# CITY OF PORTLAND BUILDING PERMIT

210 VALLEY ST

**PERMIT ID:** 2012-65554

has permission to **Buildout basement - Adding two bedrooms**

**UNIT 1 additional 2 rooms in basement**

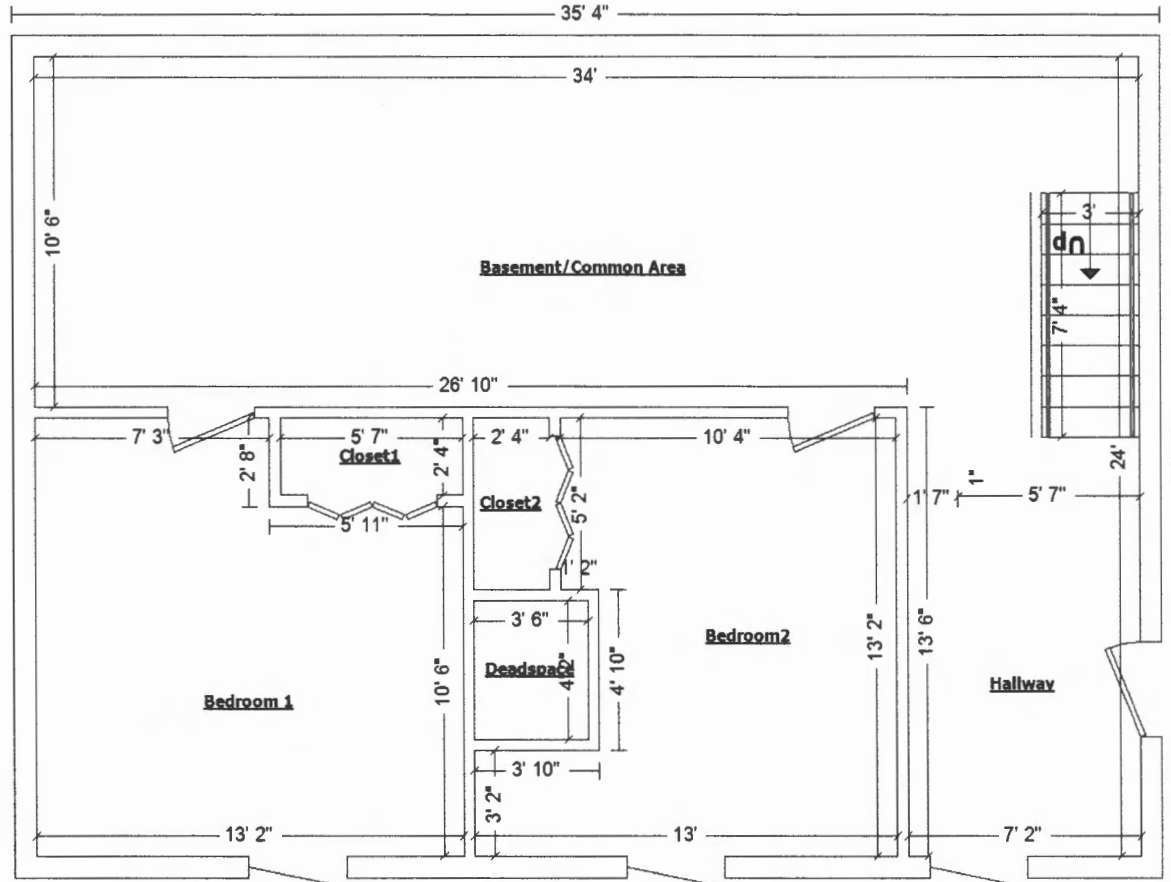
I met with Mike on the site today regarding the existing stair to the basement. In your e-mail of 1-7-2013 you state: "There current dimensions are 8 feet of stairwell at 3'2" wide". This was taken as headroom of 8' and stair width of 3'2". I don't believe that either of this is accurate. Please verify the headroom and width and provide those numbers to the Plan Reviewer. Existing conditions may be allowed to remain, however, the records must be accurate.

addressing them. Their current dimensions are 8 feet of stairwell at 3'2" wide. Please let me know if we are required to bring them to a proper code as it will drastically effect our scope of work.

Cross Section of Basement walls 210 Valley St, Portland Maine

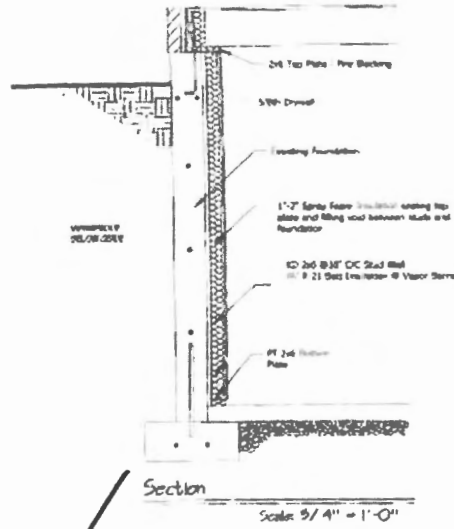
Prior to building permit issuance, our office needs a cross section of the typical wall detail, columns, and concrete work. Below are items that need to be identified on the plan.

Unless there is some reason to use all PT framing that I am not aware of, we would frame the 2 x 6 walls in the basement using KD lumber, with PT for the sill plates only.

- Is the egress casements window well(s)? What is the finish height from grade? **Low E Vinyl Casement windows RO 31.75 x 54.75 per Harvey Building quote supplied. Sill heights are 38" from floor grade.**
- Where are the doors for each proposed bedroom located? **Corrected drawing submitted**
- What is the "Deadspace" build-out in bedroom 2? **There is a non-working chimney in the basement**
- Ventilation of this space is required per ASRAE 62.2 , 2007 edition. Insulation shall comply with the IECC, 2009 (Maine State Energy Codes). **Submitting quote from Casco Bay Insulation. The exterior walls will be studded out with 2x6 PT framework. There will be a variance of 1 to 3 inches of foam sealing stud work to exterior walls and a minimum of 1 inch spray foam between studs. The bays will have added R21 to both meet and exceed current code requirements.**
